Item No. **Report of the Head of Planning, Building Control, Sport & Green Spaces**

Address THE DE BURGH ARMS AND O J'S NIGHT CLUB STATION APPROACH
YIEWSLEY

Development: Use of car park as a hand car wash

LBH Ref Nos: **8053/APP/2014/909**

Dwg Name: PROPOSED HAND CAR WASH LAYOUT

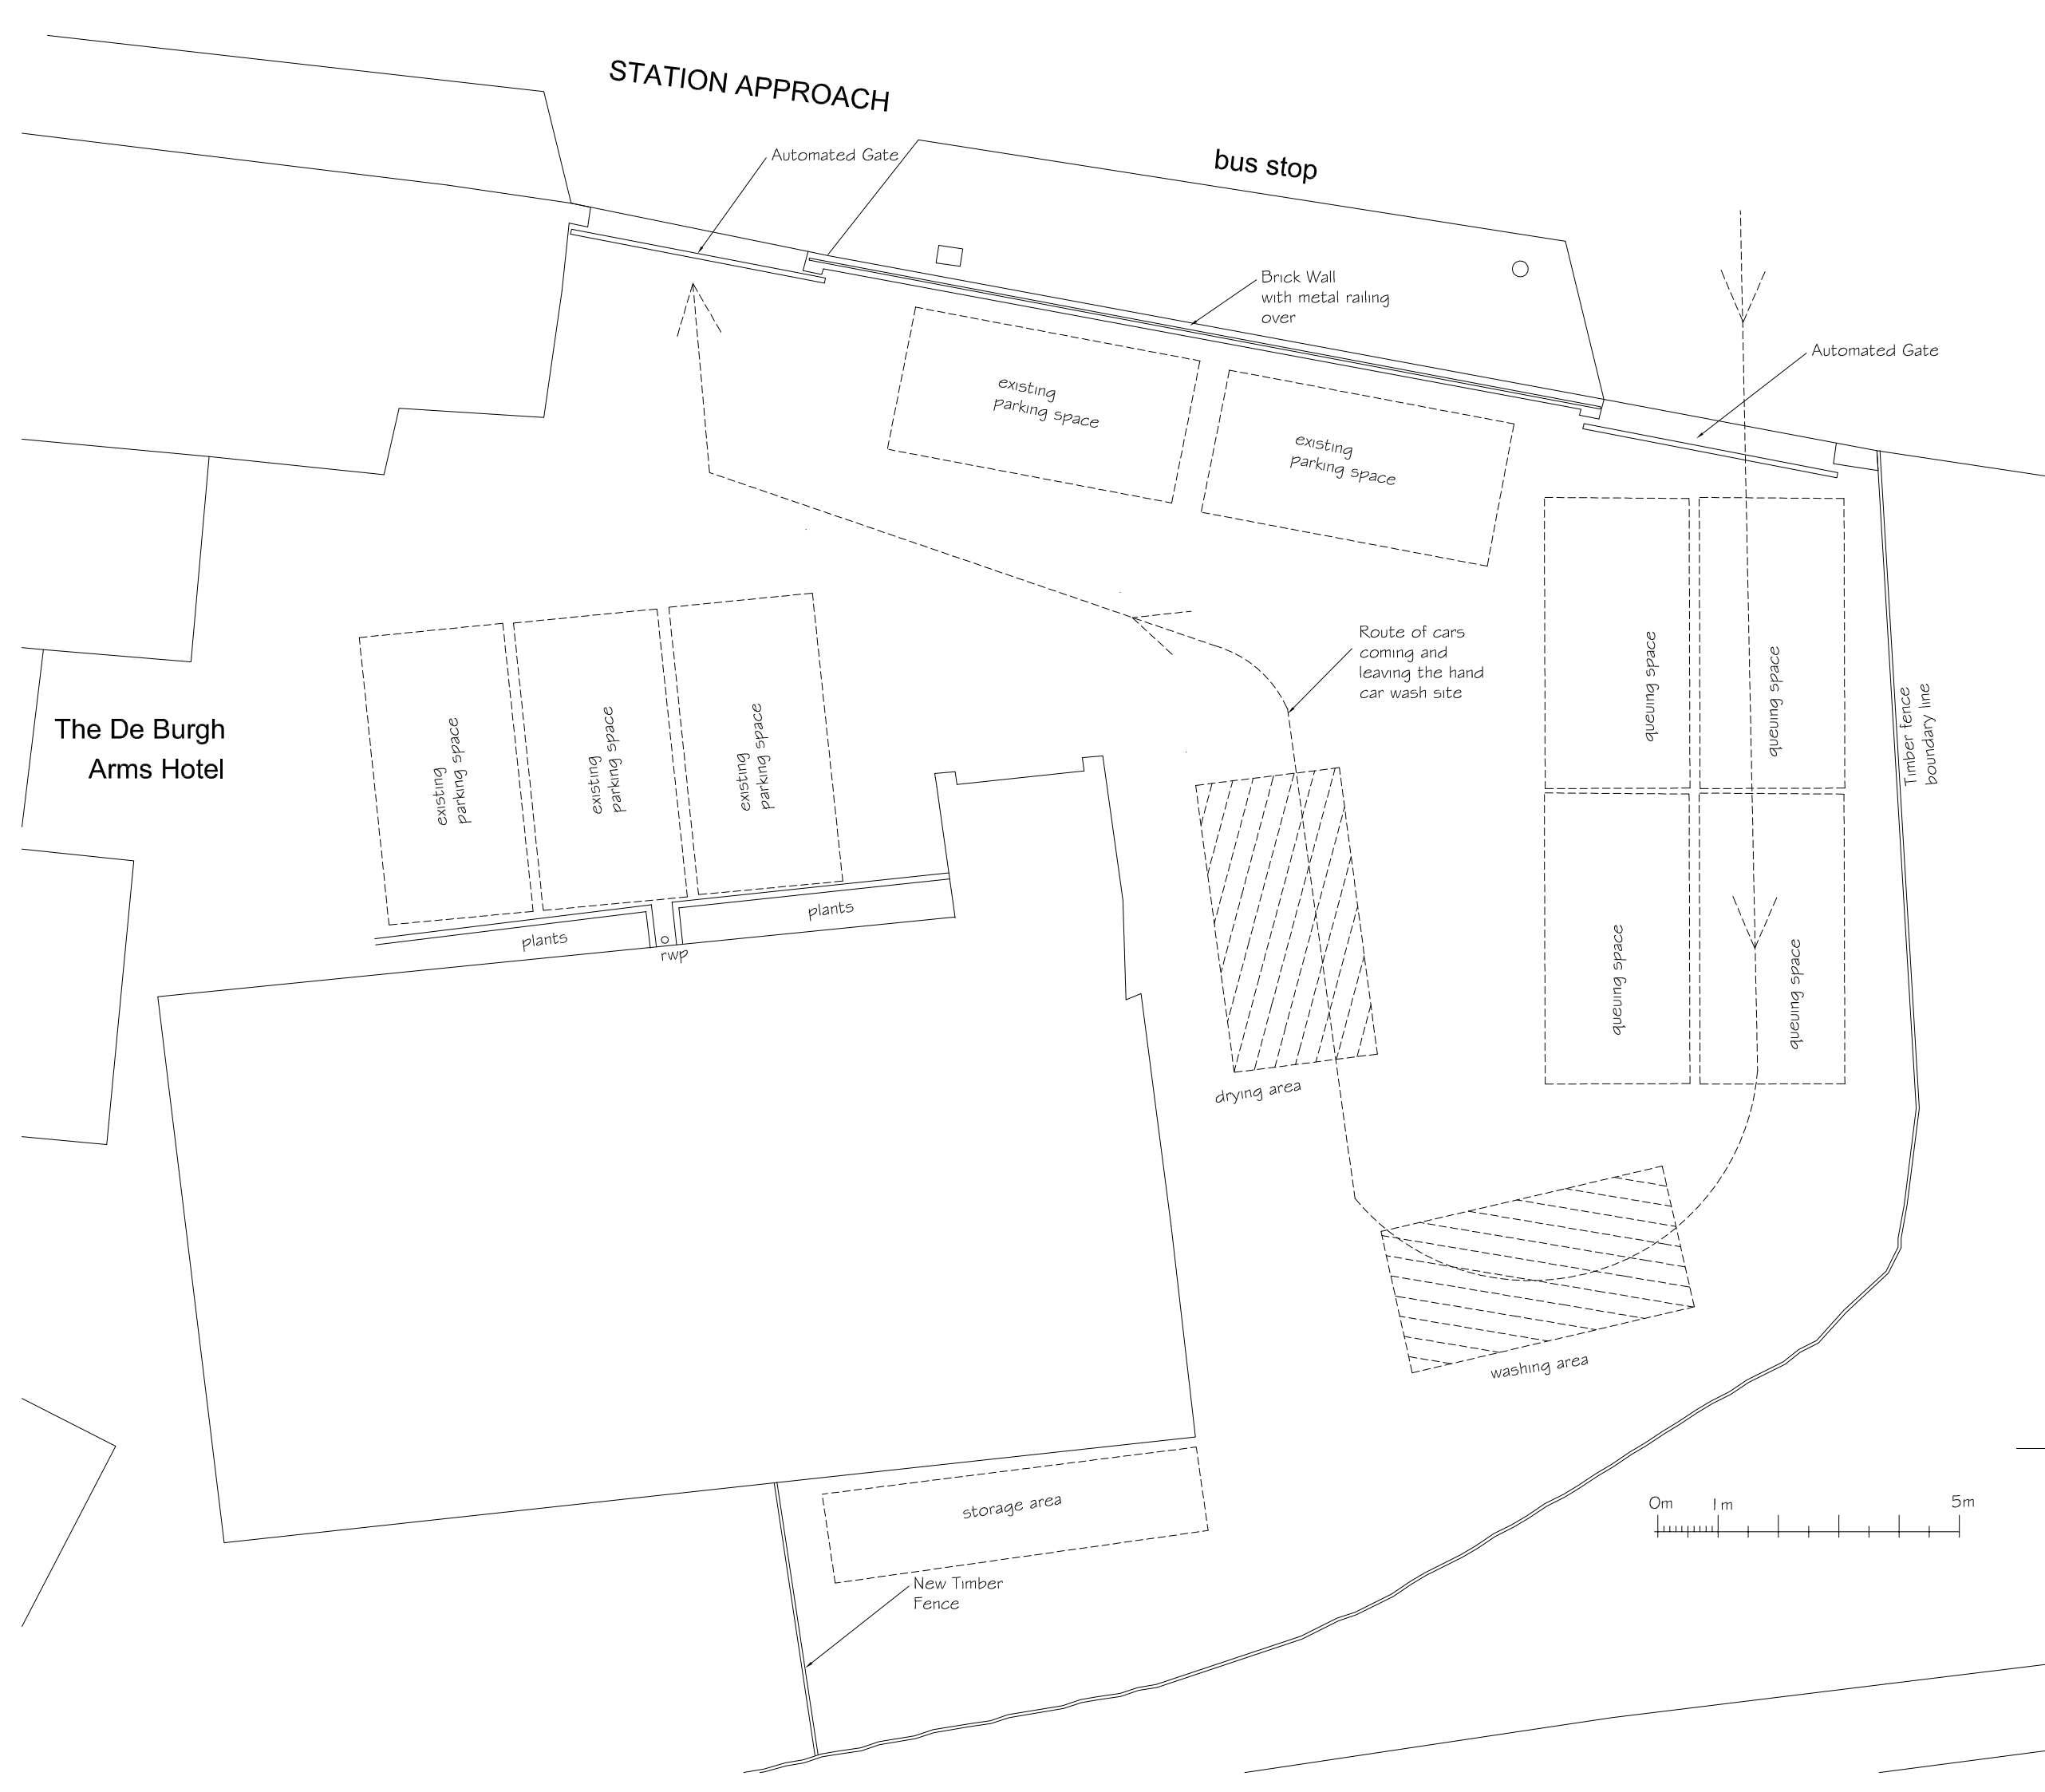
The development is for part change of use of a car park that currently serves an existing public house and adjacent nightclub, to provide a hand car wash facility within the site. Under the proposals, 4 No. car parking spaces will be retained for the use of the public house and nightclub. Access to the proposed car wash facility and the retained car parking spaces will be provided via the existing points of vehicle access, which will be operated as a one way system, providing separate access and egress.

When considering the means of access to the site, it is noted that there is no visibility along the adjacent footway and only limited visibility along the adjacent carriageway. In addition, there are a number of bus stops located directly outside of the site, which when occupied, block visibility along the adjacent carriageway and vehicle access/egress to/from the site. Furthermore, the proposals will generate additional car parking demand and intensify the use of a substandard access in a location, which will be even more busier when the Crossrail project is in operation. In addition, vehicles will be required to queue along the adjacent highway to gain access to the site, when buses are dropping off/picking up passengers, which would be detrimental to road safety and the free flow of traffic.

The proposed hand car wash would fall within the curtilage of the structure, and take up much of the current car park, which is hard surfaced, cramped in appearance and detracts from the setting of the listed building. A hand car wash would not enhance the situation and with the addition of the equipment and ad hoc advertising etc associated with these uses, would be likely to make the situation even worse.

Objection on the grounds of detrimental impact on the setting of this listed building.

The development is for part change of use of a car park that currently serves an existing public house and adjacent nightclub, to provide a hand car wash facility within the site. Under the proposals, 4 No. car parking spaces will be retained for the use of the public house and nightclub. Access to the proposed car wash facility and the retained car parking spaces will be provided via the existing points of vehicle access, which will be operated as a one way system, providing separate access and egress. There will be a reduction of approximately 5 car parking spaces that currently serve the existing public house and adjacent nightclub. However, no information has been submitted in relation to the current parking demand to justify the loss of car parking. As such, the proposal would result in the loss of 5 parking spaces currently used by the night club/pubic house use of the site and would therefore fail to provide sufficient off street parking provision which meets the council's approved parking standards to service the approved uses. The development would therefore lead to additional on street parking to the detriment of public and highway safety and is therefore contrary to Policies AM7 and AM14 of the Hillingdon Local Plan: Part Two - Saved UDP Policies (November 2012) and the Council's adopted car parking standards.
